WEST SUSSEX COUNTY COUNCIL CONSULTATION

TO:	Arun District Council FAO: Mr. S. Davis
FROM:	WSSC – Highways Authority
DATE:	7 November 2025
LOCATION:	Land Adjacent to Woodgate Nurseries Lidsey Road Aldngbourne PO20 3SU
SUBJECT:	AL/93/25/DOC Approval of details reserved by condition imposed under reference AL/129/21/OUT relating to condition 14 - construction & environmental management plan.
DATE OF SITE VISIT:	21 October 2025
RECOMMENDATION:	Advice

Dwg No: H9390-SEP-01

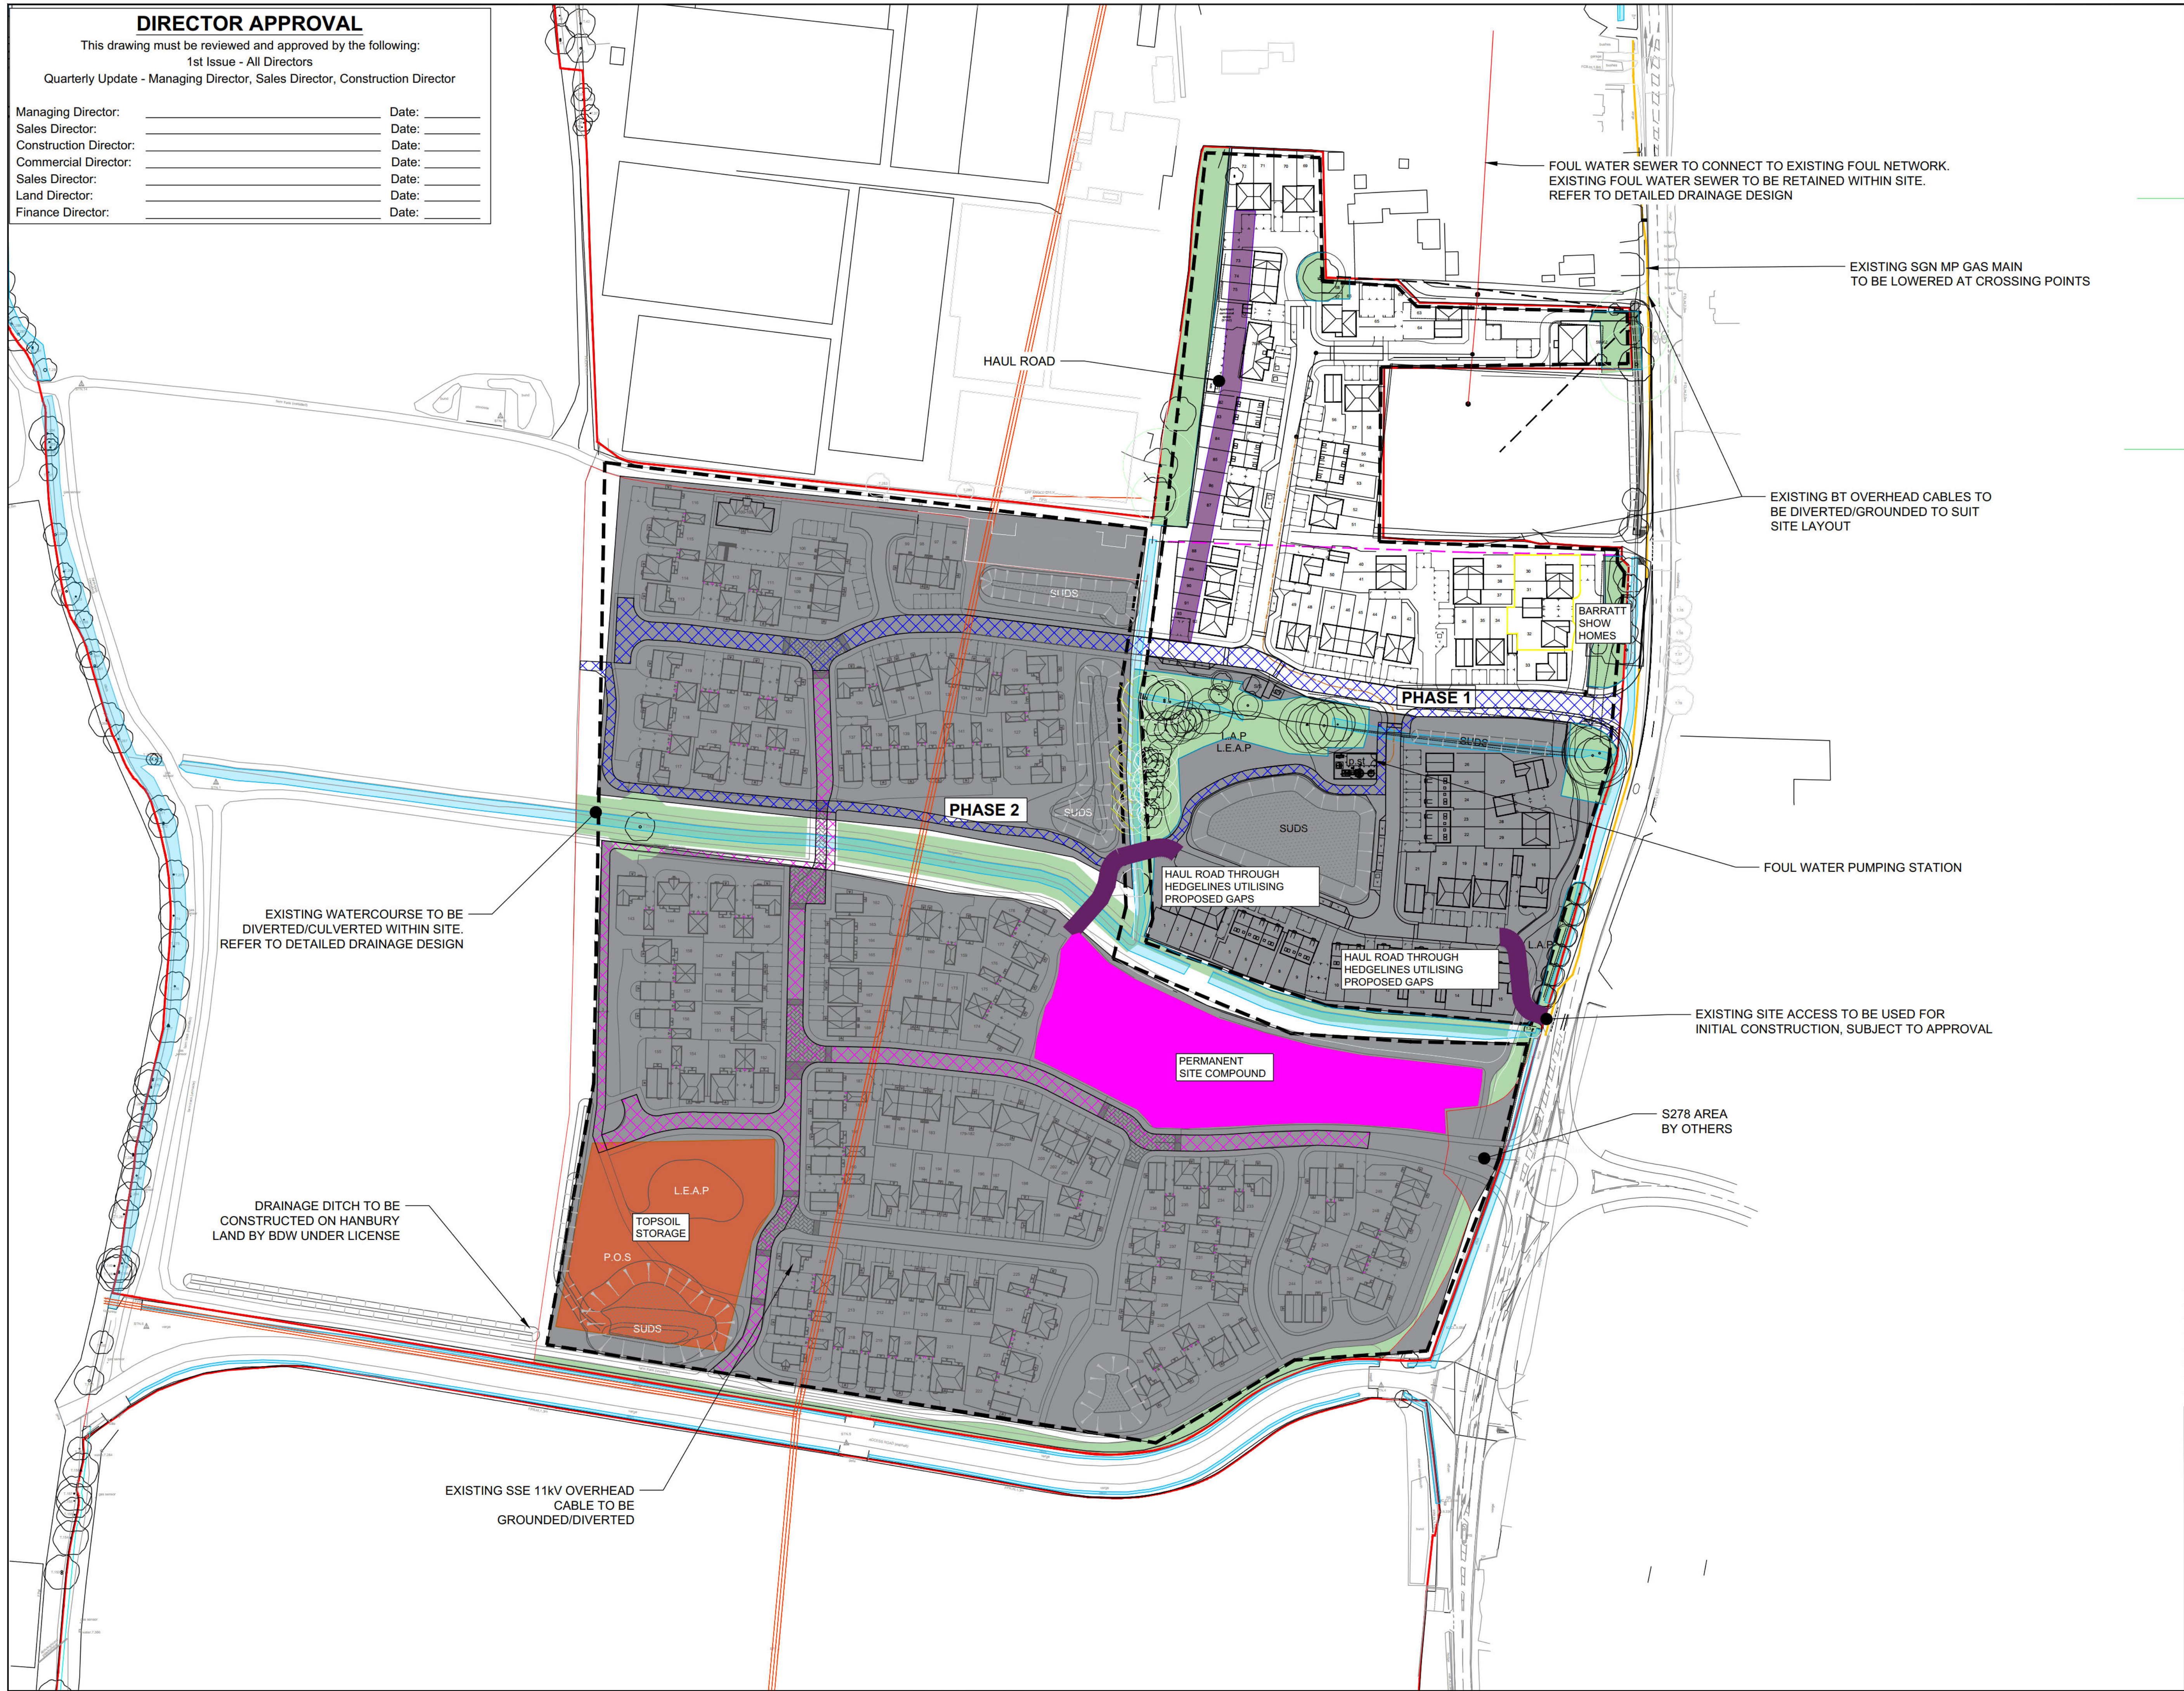
In its previous response, the Highway Authority identified that a plan still showed one of the possible construction access points being off the former Lidsey Landfill access found south of the application site. Although the text in the CEMP (Revision 'D') removed reference to it, a plan in the document (Drawing No. H9390-SEP-01) still showed it.

In the latest version of the CEMP (Rev E), the applicant has confirmed that the 'Execution Plan' has been amended to remove all references to use of the existing site access leading off the Lidsey Landfill track/road.
